Post Installation Report

Hampton Park - Littlehampton

Inspection Ref: 1339409

## Hampton Park - Littlehampton - LEAP

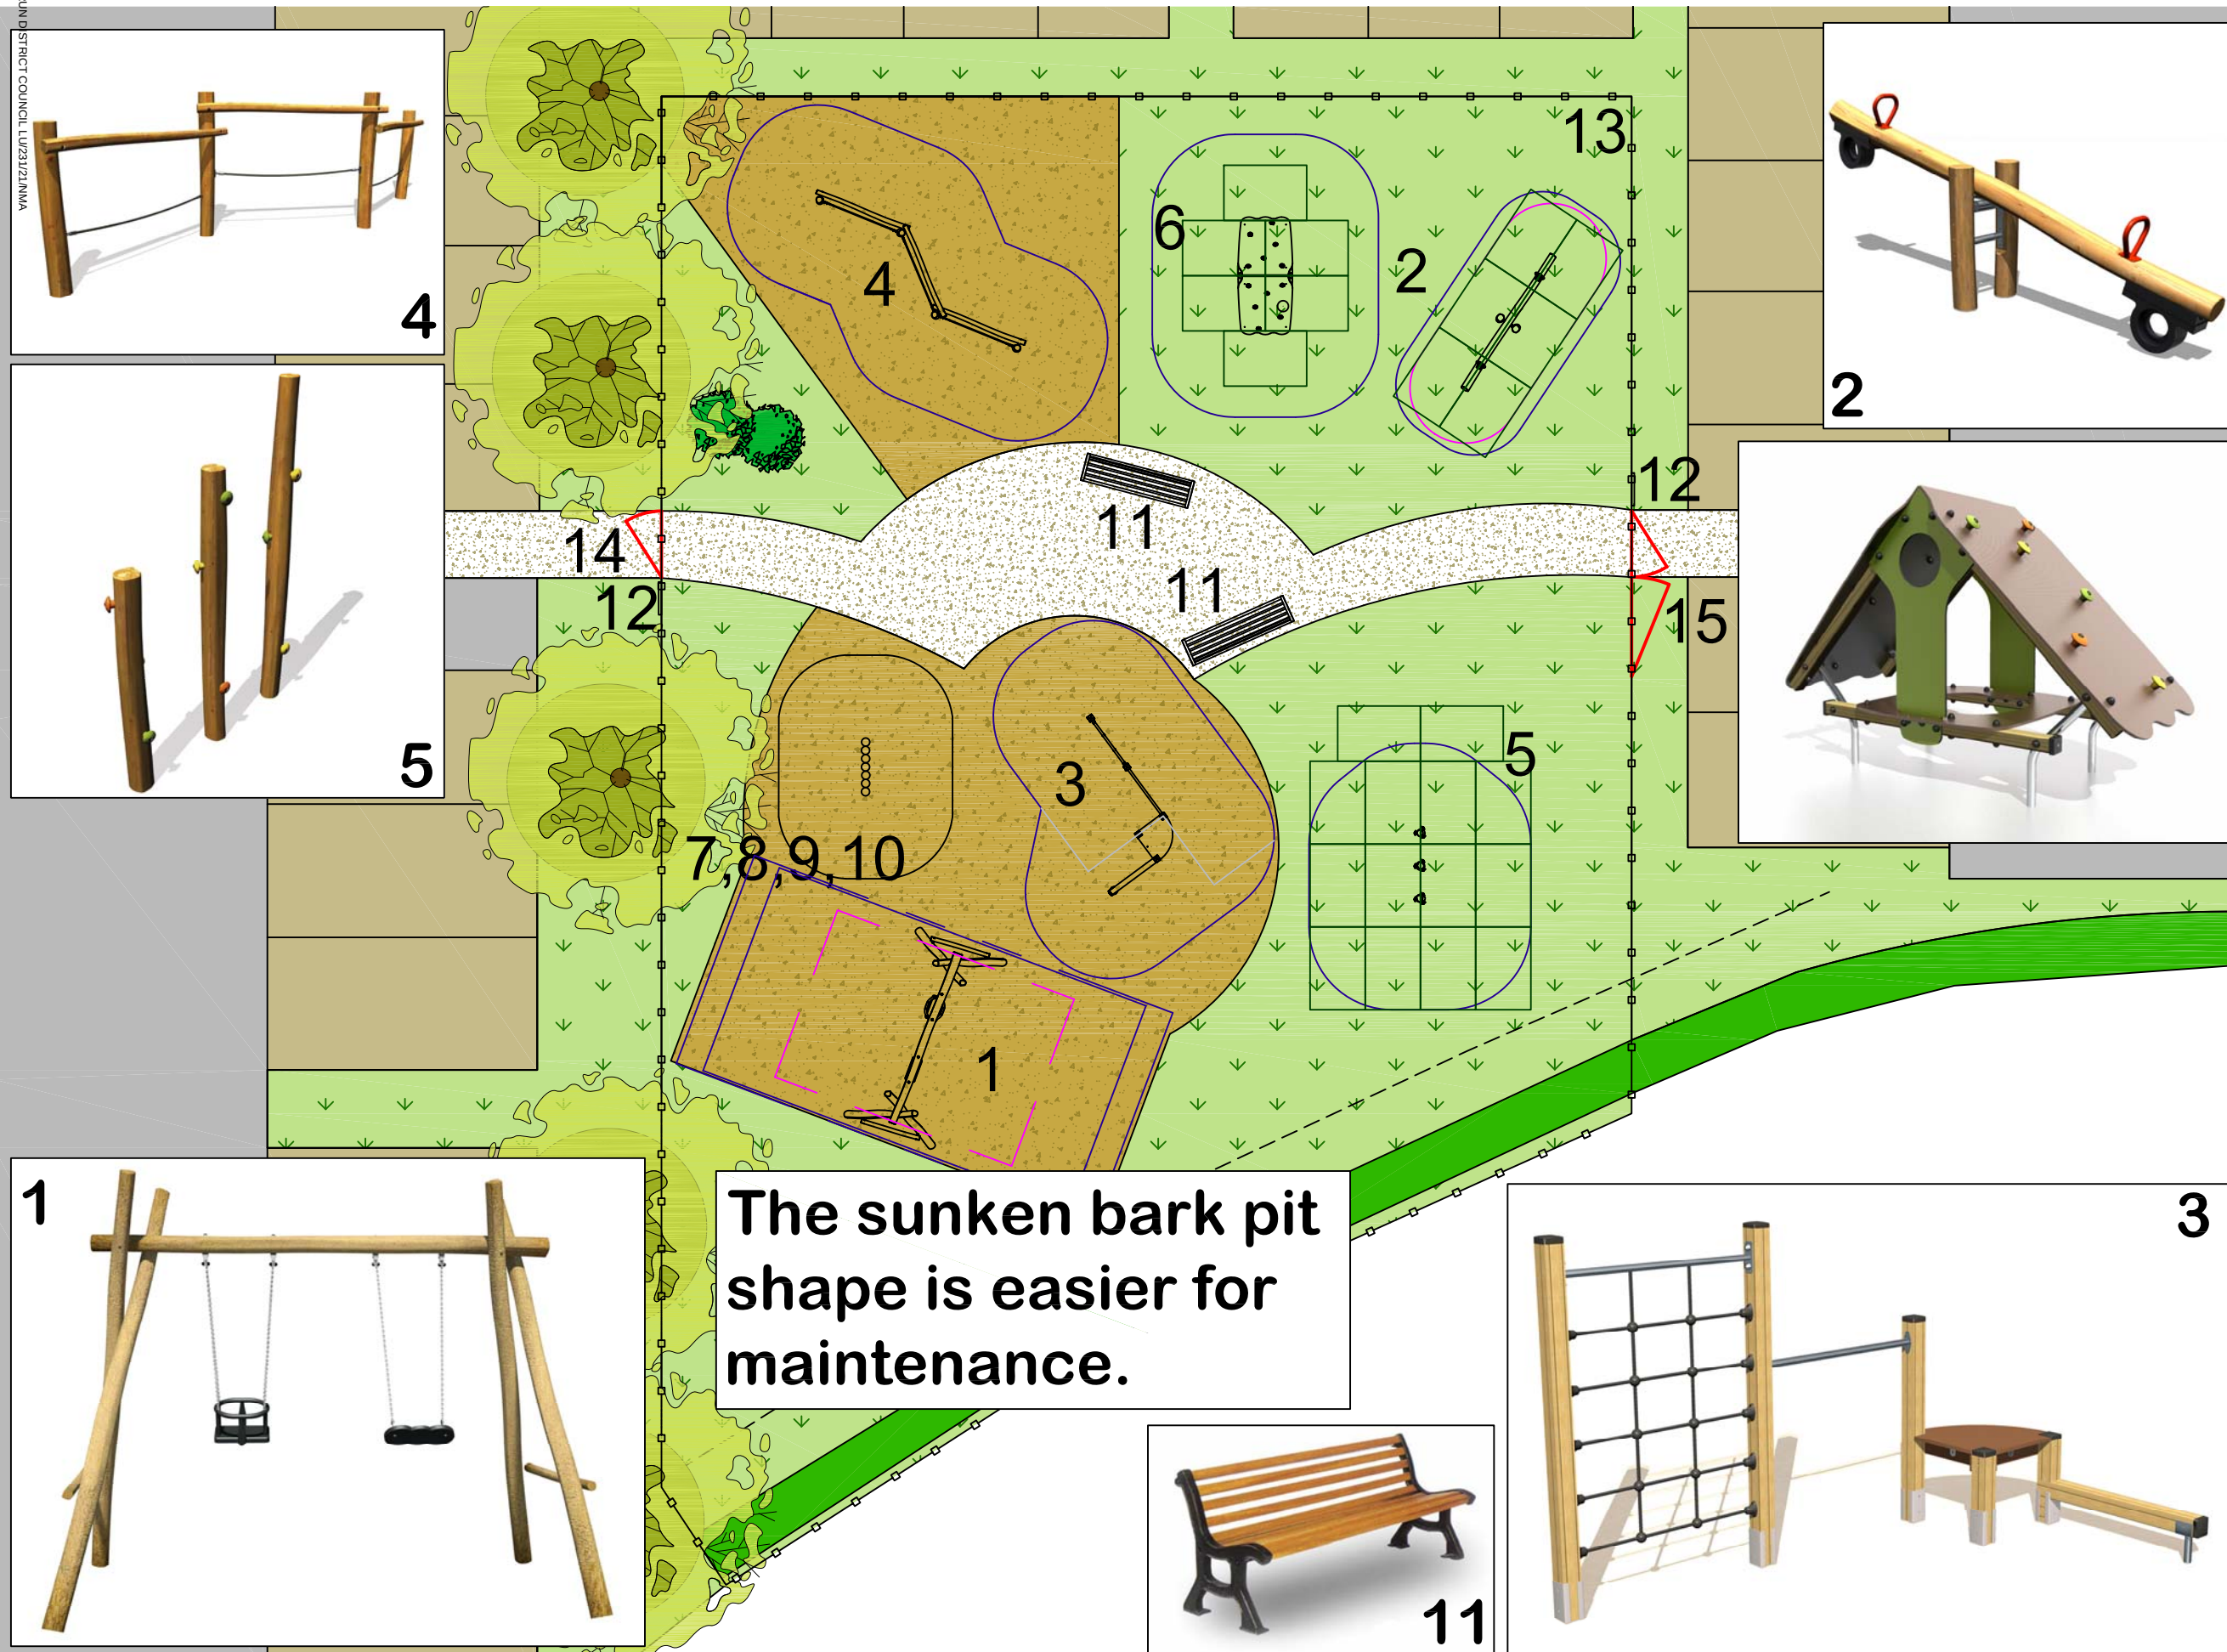
Finding 1	Finding 2
The pathway was unfinished at the time of inspection and there are a number of holes in the surface creating trip hazards - Complete installation of pathway	NOTE - this report has been updated on the 7th July 2021 based on an image and written confirmation of works provided by the contractor after the inspection took place -

There is no padlock on the maintenance gate - Provide a padlock to secure the gate

The adjacent foliage forms a hard sharp object within the falling space of the equipment in contravention of the requirements of BS EN 1176 Part 1 - Refer to the contractor / designer
